RE: SUB19-002/SEP19-005 – Proposed Preliminary Plat
2825 W. Mercer Way, APN 2174502425
Request for Additional Information, Third Review
Blueline Job No. 13-118

This letter is in response to your review of the SUB19-002/SEP19-005 project. The plans have been revised per the comments in your letter dated 1/09/23. Below is a list of each comment with our responses in bold.

2/16/23
JOB NUMBER: 13-118
SHEET NAME: RS-01
SHT 6 OF 9

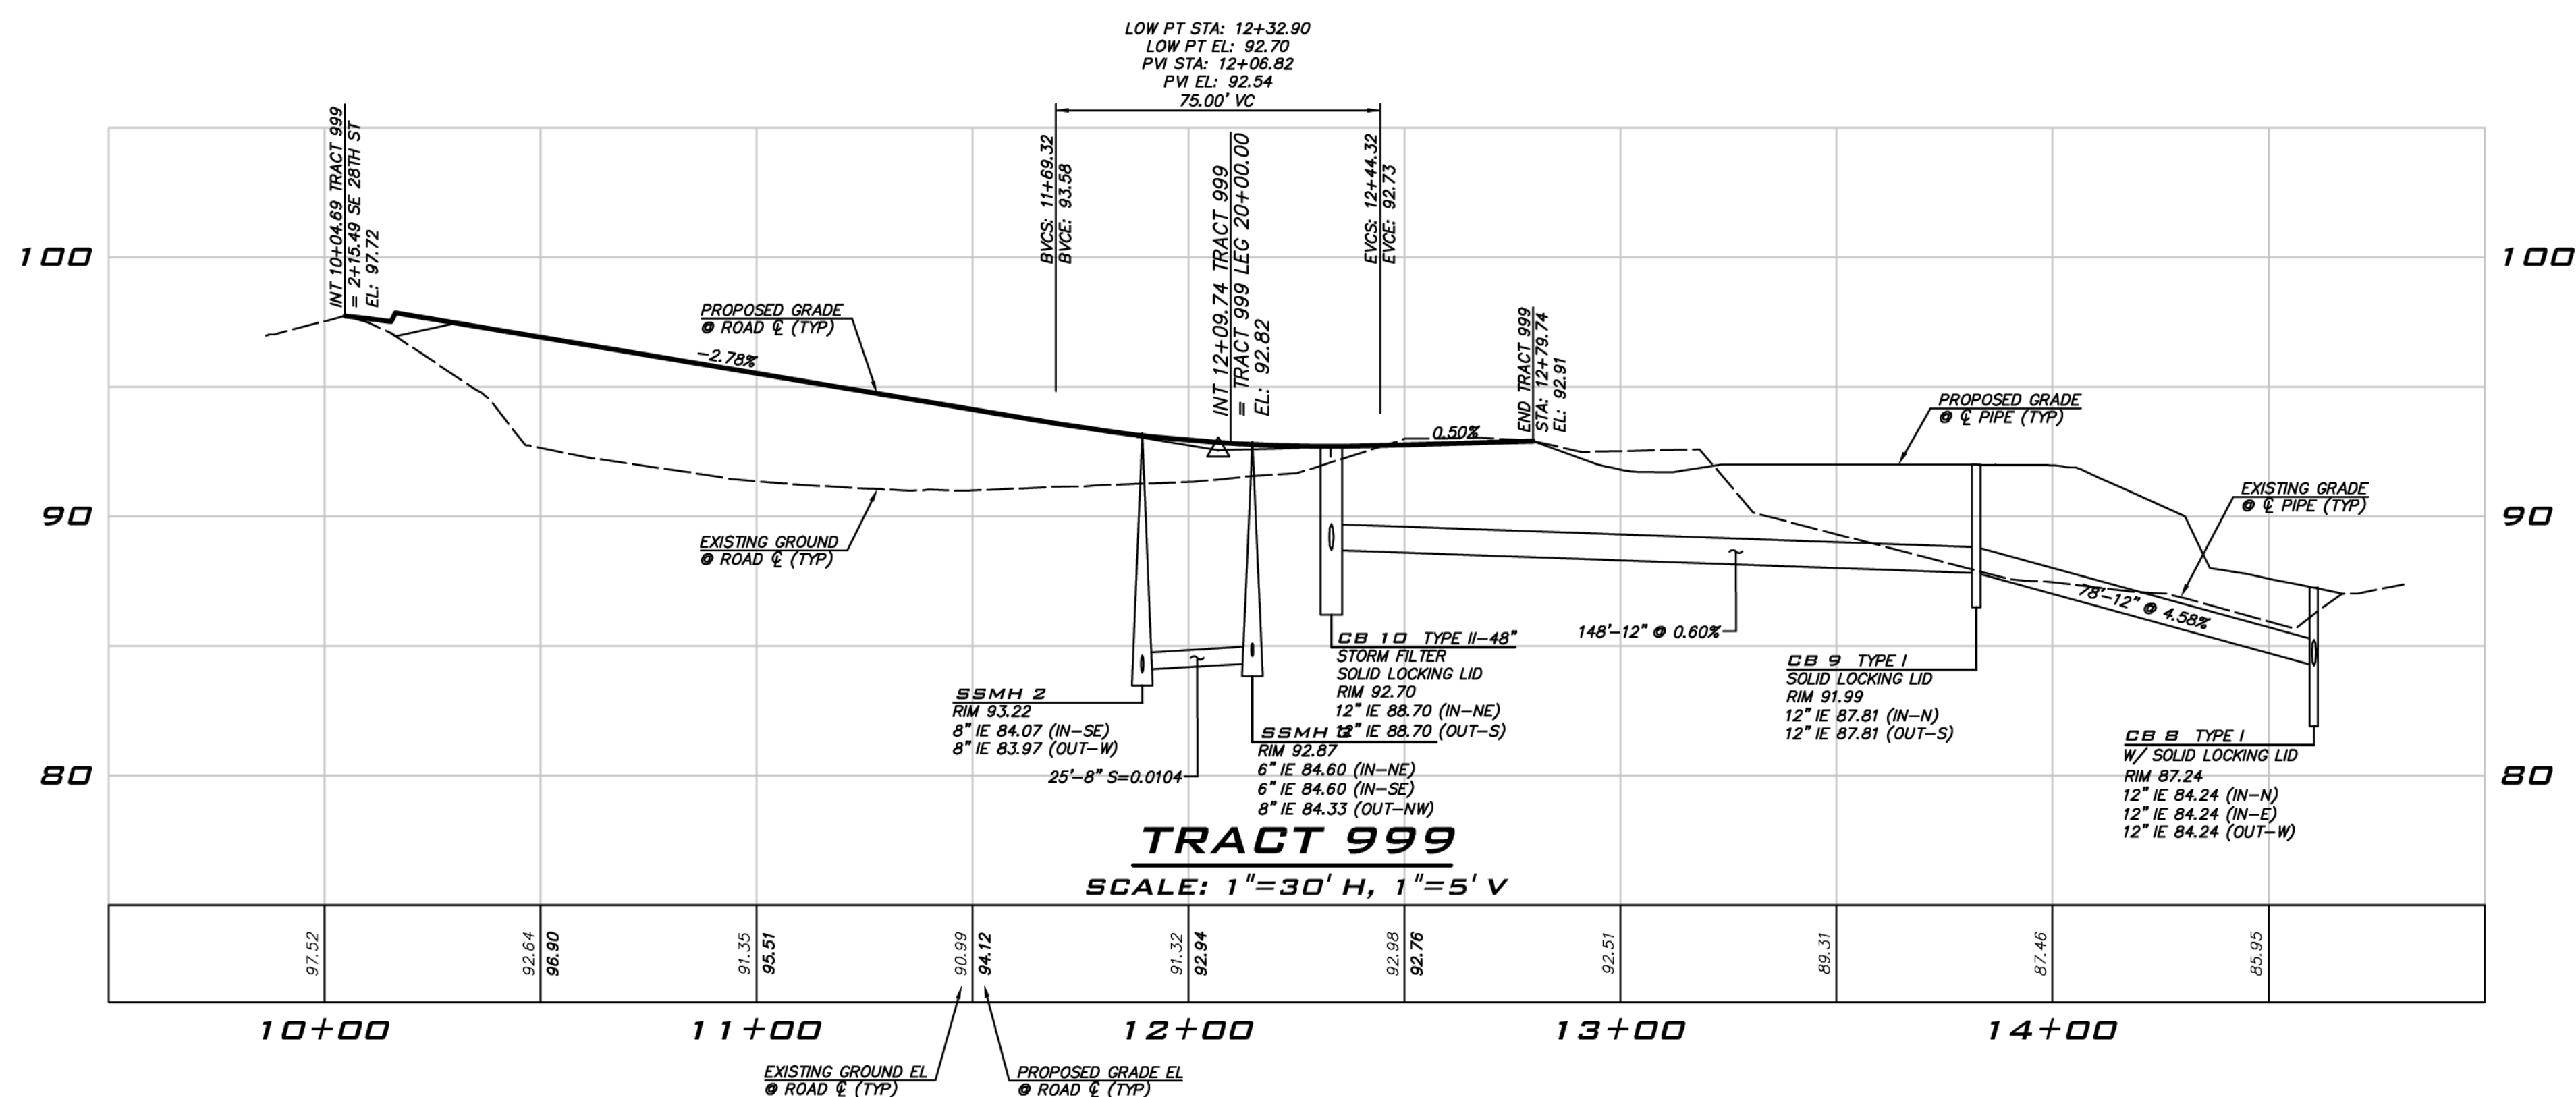
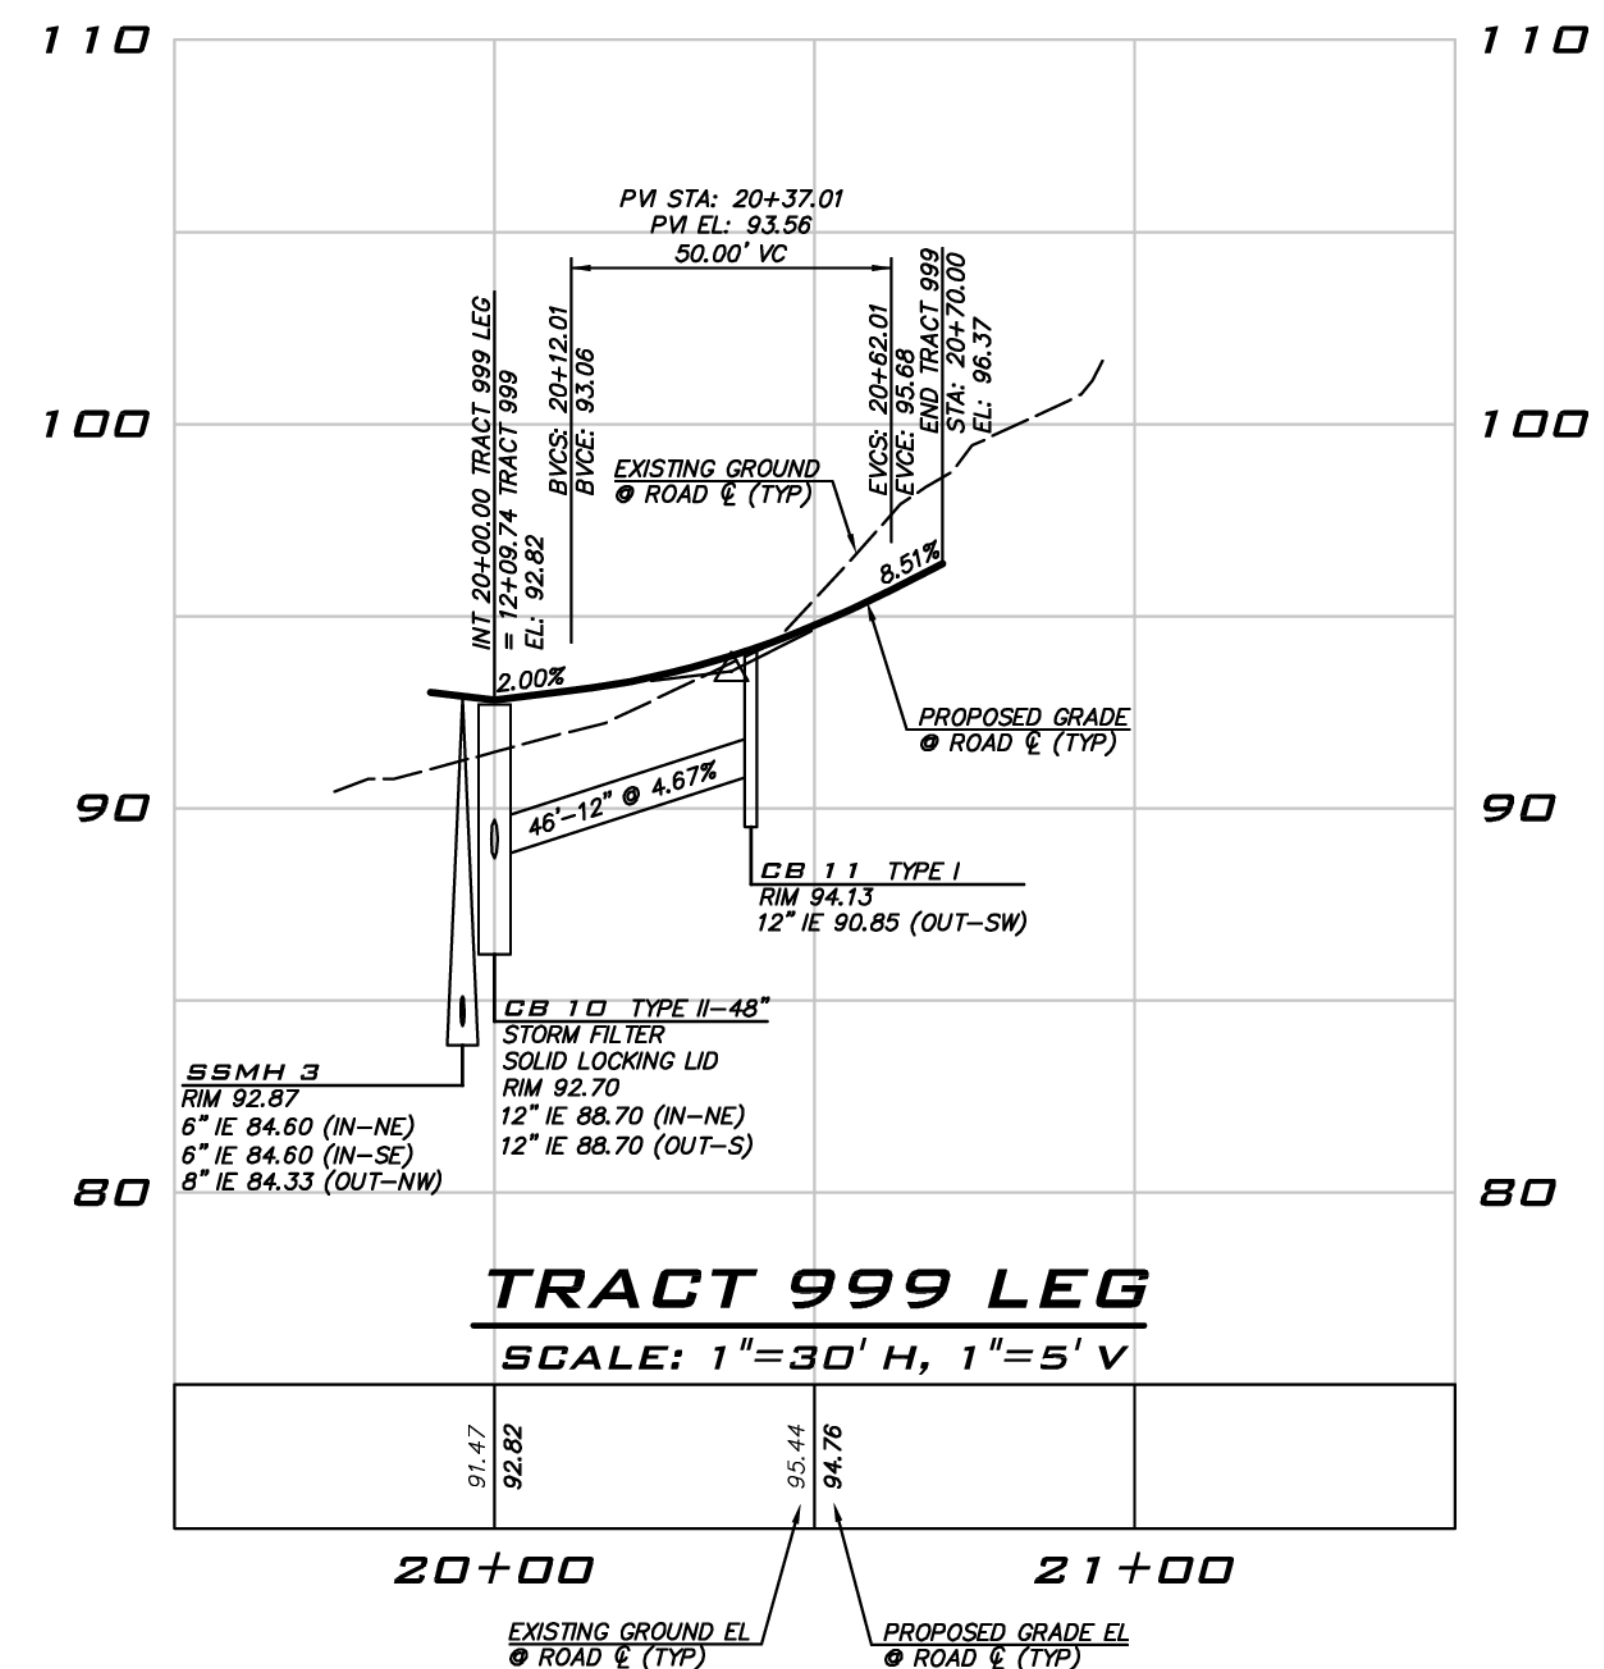
7. Fire Turn Around- Meets Standards
IFC 503.2.4 The required turning radius of a fire apparatus access road shall be determined by the fire code official. (See Appendix B)
Applicant must identify turn around area on plat map and provide a plan on how this area will be maintained for fire access only and not parked vehicles. Examples would be painted lines (maintenance agreement) and/or signage.

Noted. A callout for the fire turnaround has been added to sheets SP-01 and RS-01.
